## SICEEP, North East Plot (SSDA7) – Response to Department of Planning and Environment Submission

SCOPE OF WORKS PLAN				
STATUS				
DEVELOPMENT APPLICATION				
SCALE @ A1	DRAWN	CO-ORD	REVIEWED	APPROVED
as shown	JC	JC	JC	AB
PROJECT NUMBER	DRAWING NUMBER		REV	
005198	L201		E

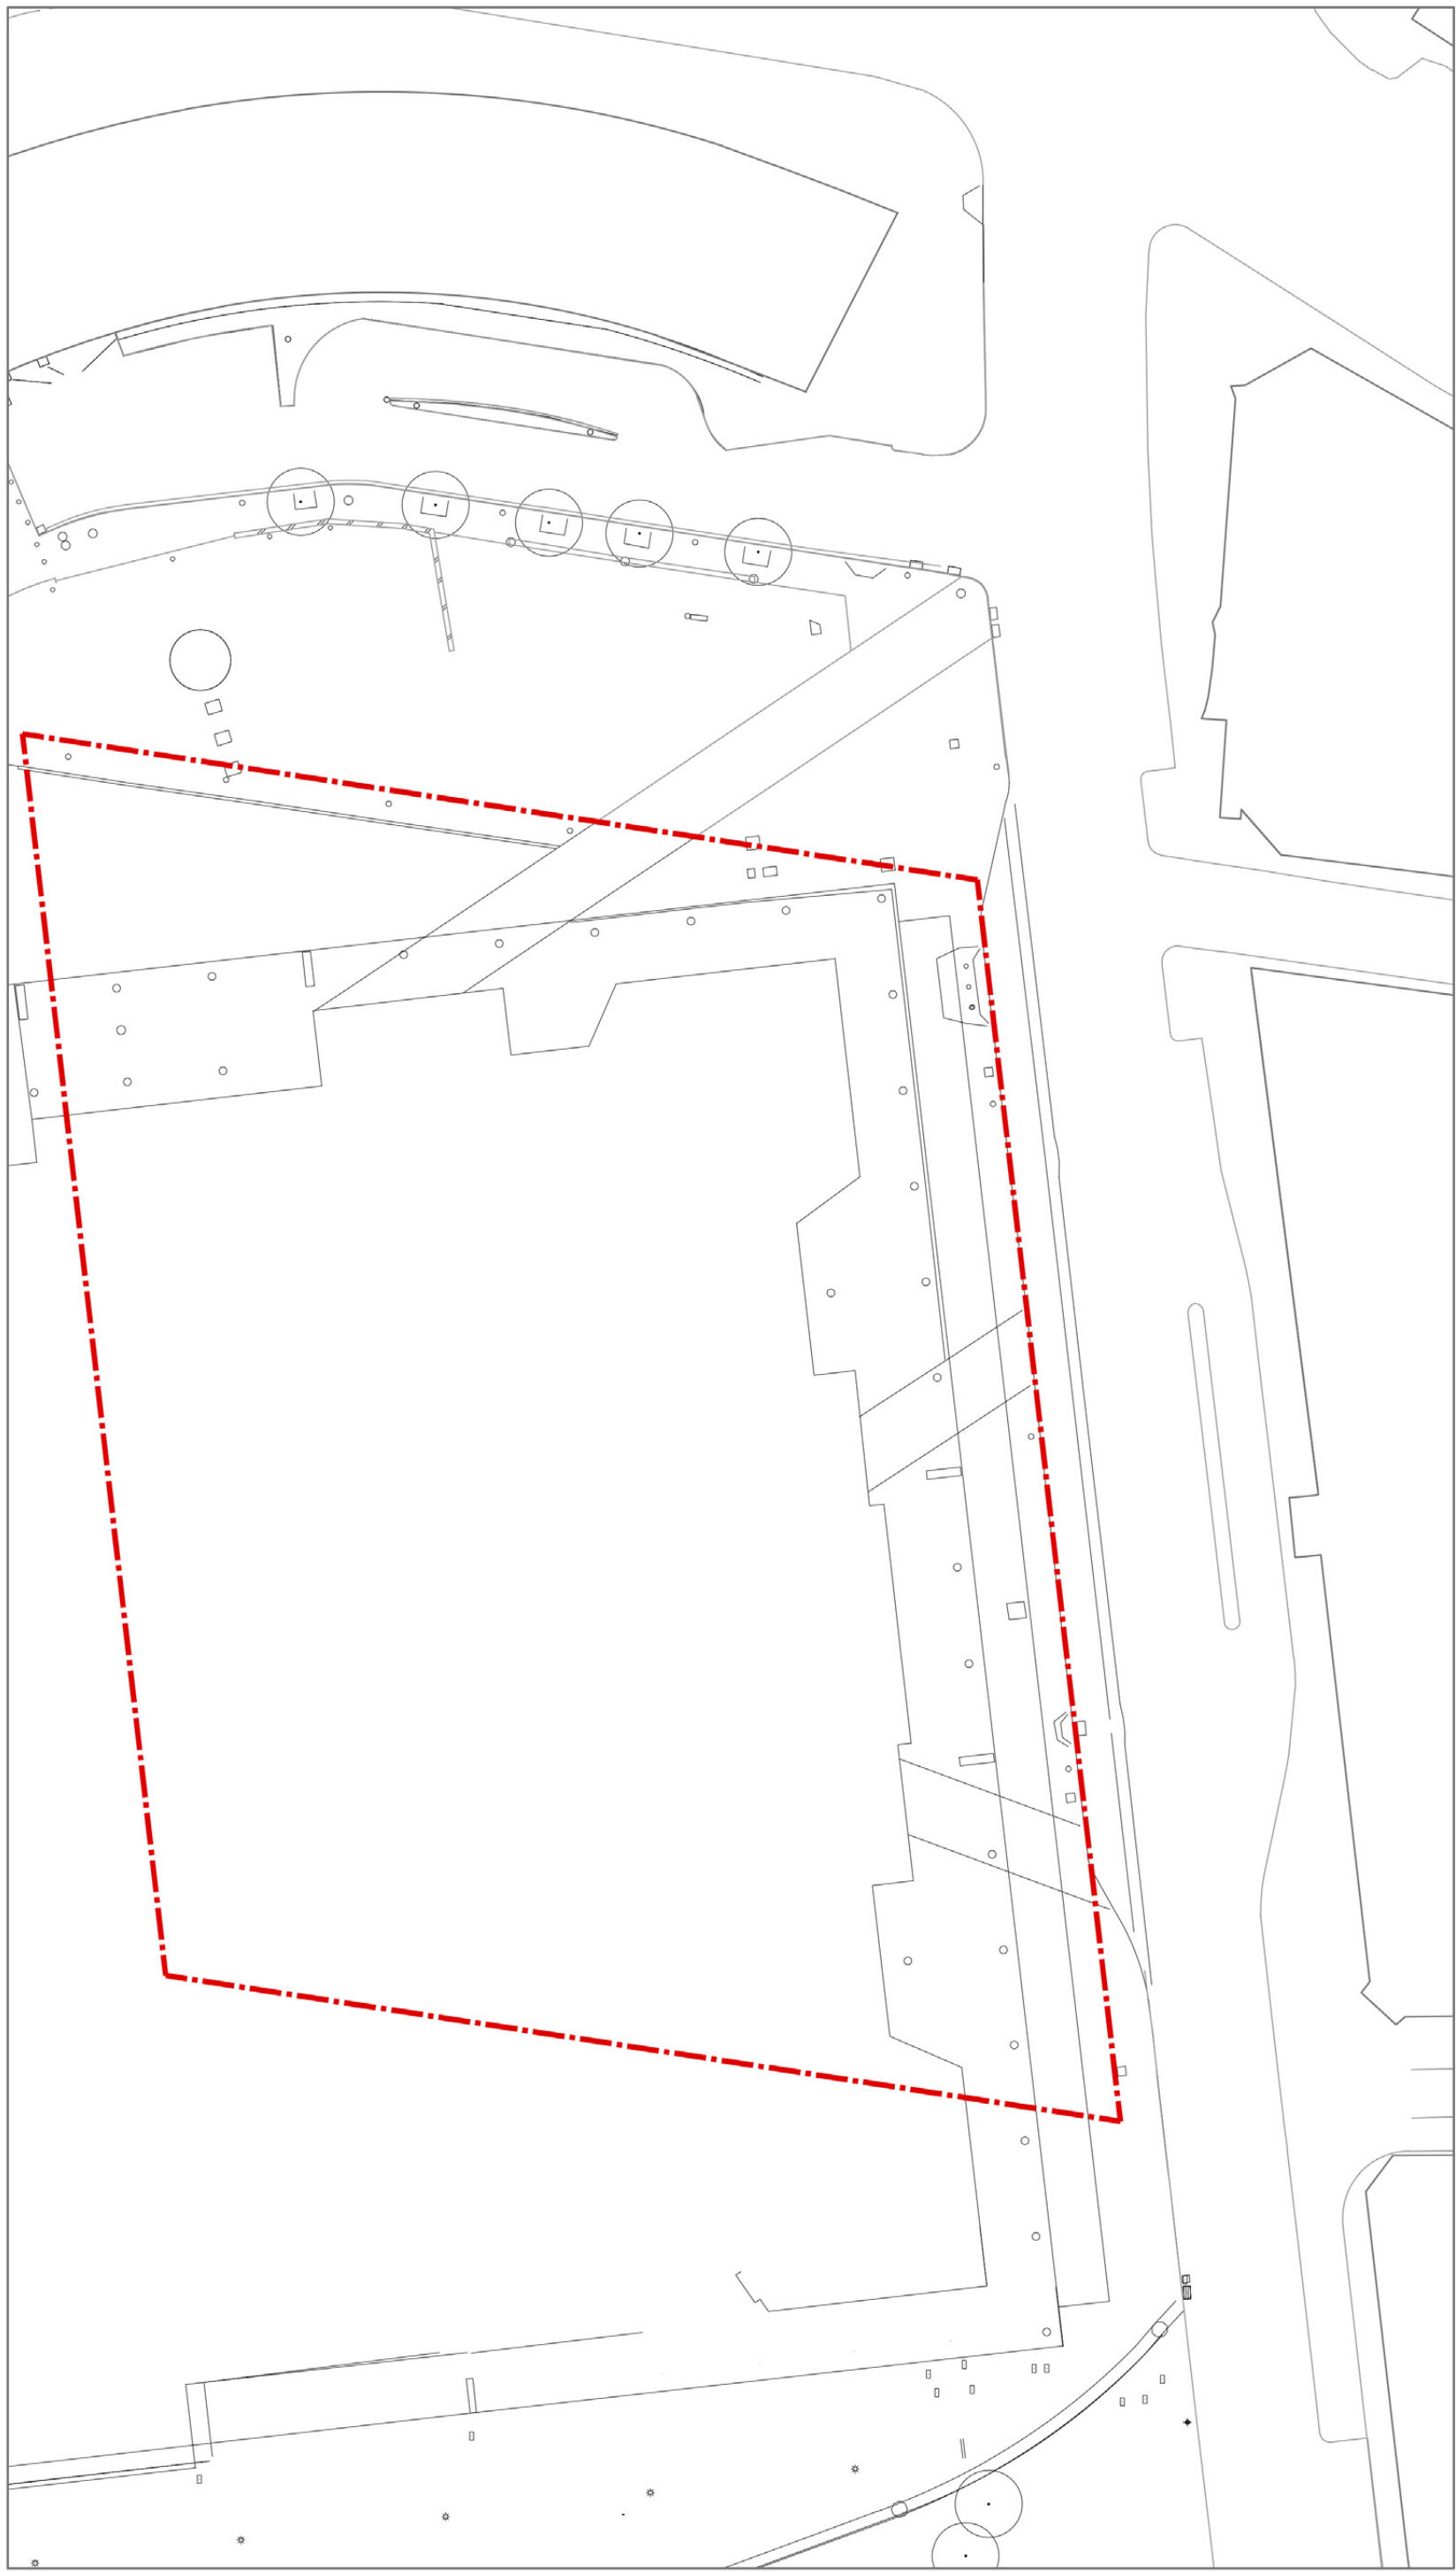
<b>Harbour Street Footpath and Layby Area</b>	
<p>3. Consideration should be given to the removal of the existing layby in Harbour Street to enable widening of the pedestrian footpath and upgrade of the public domain along this frontage. If the layby is to be retained, the following information/clarification is required:</p> <ul style="list-style-type: none"> <li>further justification for the retention of the vehicle layby area on Harbour Street given the removal of the SEC and provision of on-site servicing bays;</li> <li>plans detailing the existing and proposed vehicle layby designs, shown in context;</li> <li>confirmation of public domain treatment, including street tree planting, for the built out footpath between the proposed vehicle access and lobby of NE3;</li> <li>response to Council's comments on reducing the width of the layby area;</li> <li>confirmation of any consultation with Roads and Maritime Services; and</li> <li>confirmation of the existing layby's coach parking capacity.</li> </ul>	<p>Efforts have been made by the proponent to resolve this issue, including arranging meetings/consulting with Council (as the landowner and roads authority), Transport for NSW (including RMS) and the City Centre Transport Taskforce. The outcome from these discussions reveals that there is at present differing views (between principally Council and TfNSW) as to what the ultimate form of the layby on Harbour Street should be and the users (coach/bus vs vehicles).</p> <p>Lend Lease is committed to achieving a more pedestrian friendly environment on Harbour Street, with a draft Concept for that land along Harbour Street outside of the site boundary and owned by Council included within the Public Domain Drawing prepared by Hassell (see <b>Appendix D</b> of the Response to Submissions).</p>

<p>4. Consideration should also be given to the treatment / upgrade of finish of the western pavement of Harbour Street, from the building line to the kerb.</p>	<p>Ultimately, the final decision on the design, length, and width of the layby (which will influence the footpath width) and funding is the subject of further detailed discussion/resolution/collaboration with these key and other stakeholders (including the Central Sydney Traffic and Transport Committee) and is a matter that is able to be dealt with through the detailed design/construction phase of the project.</p>
